Our ref: DOC21/988428

Notice of Exhibition of application for MOD 1 Removal & replacement of 2 trees on Gloucester Walk (SSD-10384 - Mod-1)

**Figure 2 |** Location of Trees 50 and 51 (Source: Approved Landscape Plan Basement B2-B1)

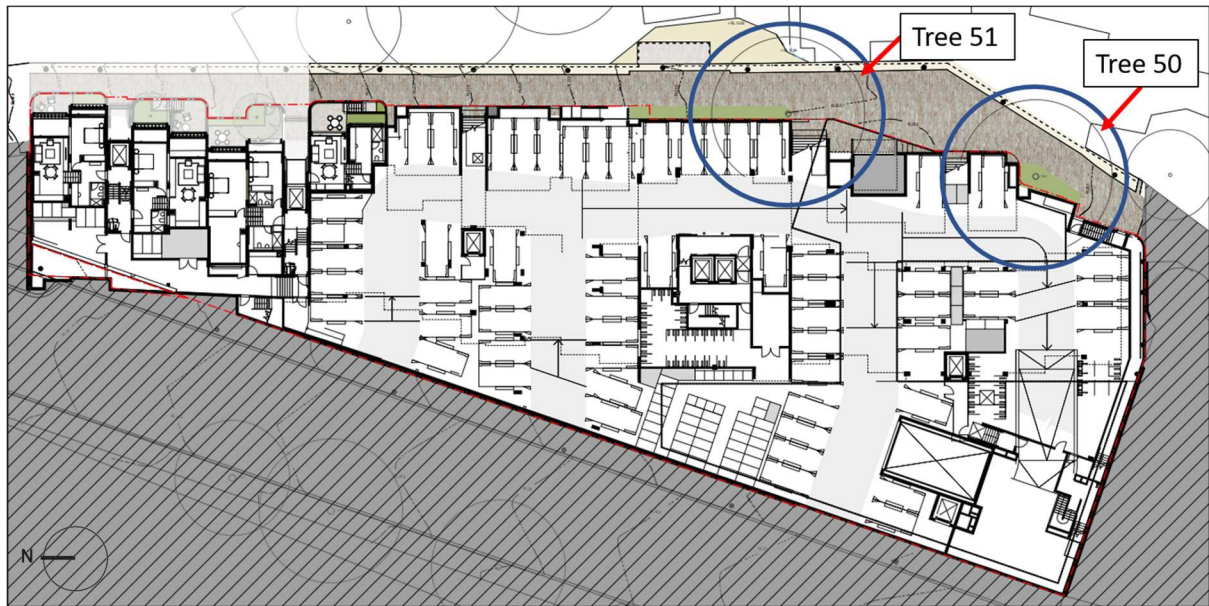
The proposed modification seeks to amend the approval to enable the removal of two *Platanus x hybrida* (Plane Trees) (Tree 50 and 51) on Gloucester Walk to allow the approved removal and reconstruction of the retaining wall on Gloucester Walk to proceed. It is proposed to replace these with new tree plantings comprising four (4) *Nyssa sylvatica* (Nyssa, Tupelo) plantings.

The submitted documentation including the Heritage Impact Statement prepared by Urbis dated 7 September 2021 has been reviewed. It is noted that the affected trees have been estimated at 20-25 years of age and do not form part of the original landscaping and setting of the site. Therefore, no objection is raised to the proposal on heritage grounds. As the works would require some excavation, condition regarding archaeology to cover for any unexpected finds is recommended.
